RE: Response to Request for Information for SSD 8858 & SSD 5175 MOD 5

Ethos Urban has prepared this letter on behalf of Frasers Property Australia in response to your letter dated 28 November 2019 and the associated submissions received during the exhibition period of SSD 8858 and SSD 5175 MOD 5, relating to Stage 2 of the Eastern Creek Business Hub development.

6.4m SMALL RIGID VEHICLE
SWEPT PATHS

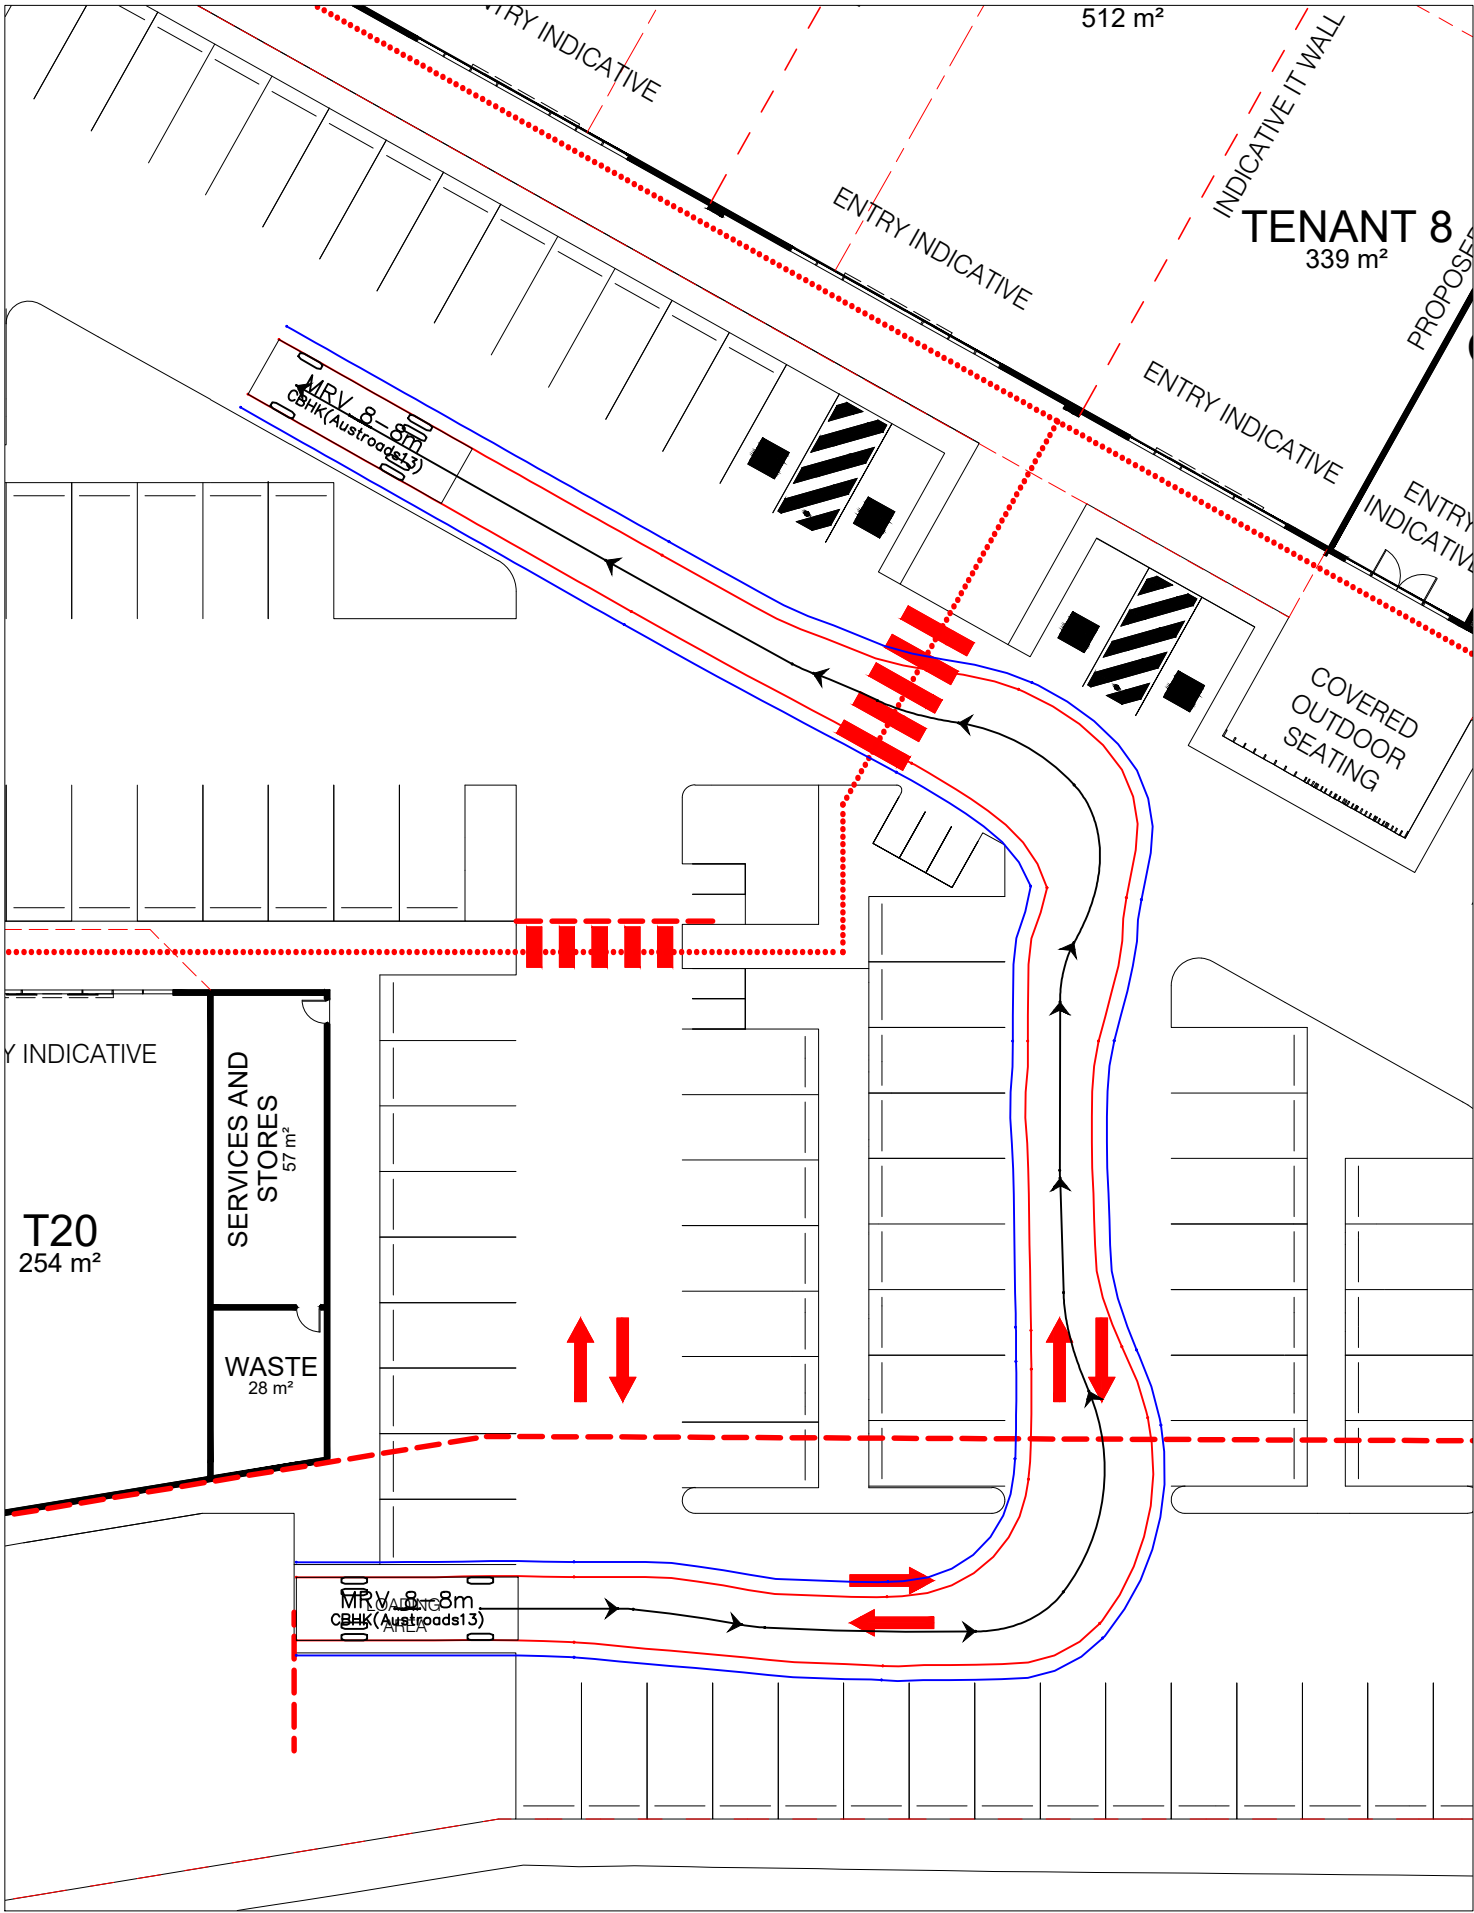
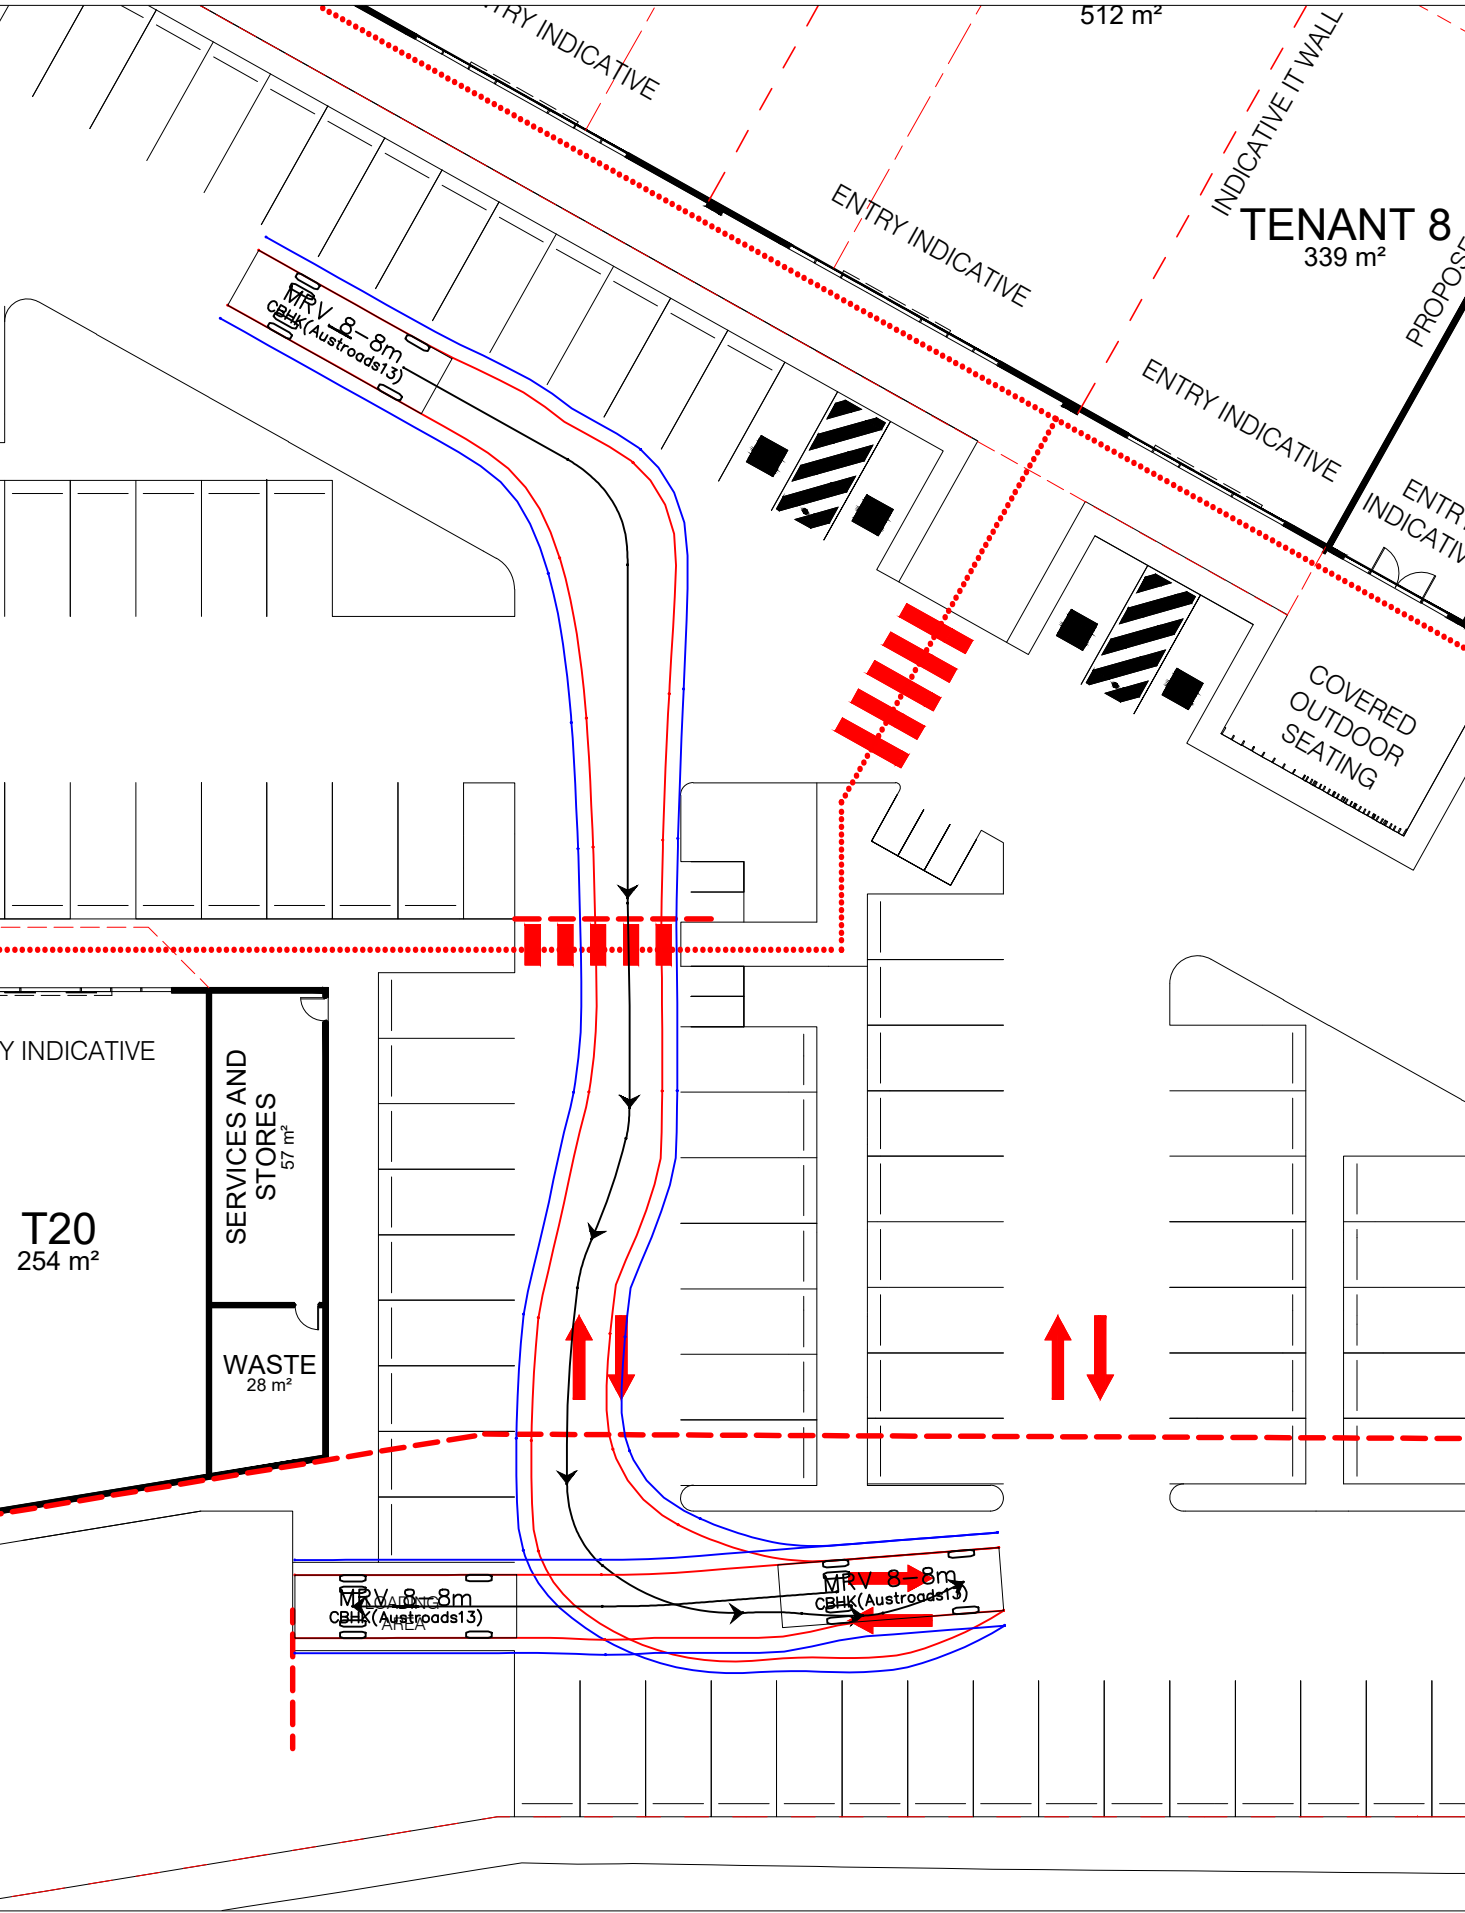
Comment	Action
indicate where the smaller service vehicles will park and demonstrate there is sufficient space for these vehicles to manoeuvre within the carpark.	Two new loading bays for smaller service vehicles are proposed to the west of Building 2 and south of Building 3. The Architectural Plans and Traffic Impact Assessment have been updated to reflect this (Attachments G and D). The Traffic Impact Assessment includes swept path diagrams which demonstrate that there is sufficient space for these vehicles to manoeuvre within the carpark.
Traffic report Update the GFA figures associated with the proposal at paragraph 1.6. It is noted the GFA figures add up to 11,598 m², which is greater than the proposed GFA of 11,358 m² - Update the parking requirements at paragraph 2.13, which rely on the incorrect GFA figures - Provide further detail of expected frequency of loading/delivery and waste vehicle movements to service the site - Clarify how the indoor recreation centre traffic generation rate has been developed - Update the key findings of the Traffic Report at paragraph 2.47 to correctly refer to the proposed GFA and uses at Lot 1.	An updated Traffic Impact Assessment has been prepared to respond to these matters (Attachment D).
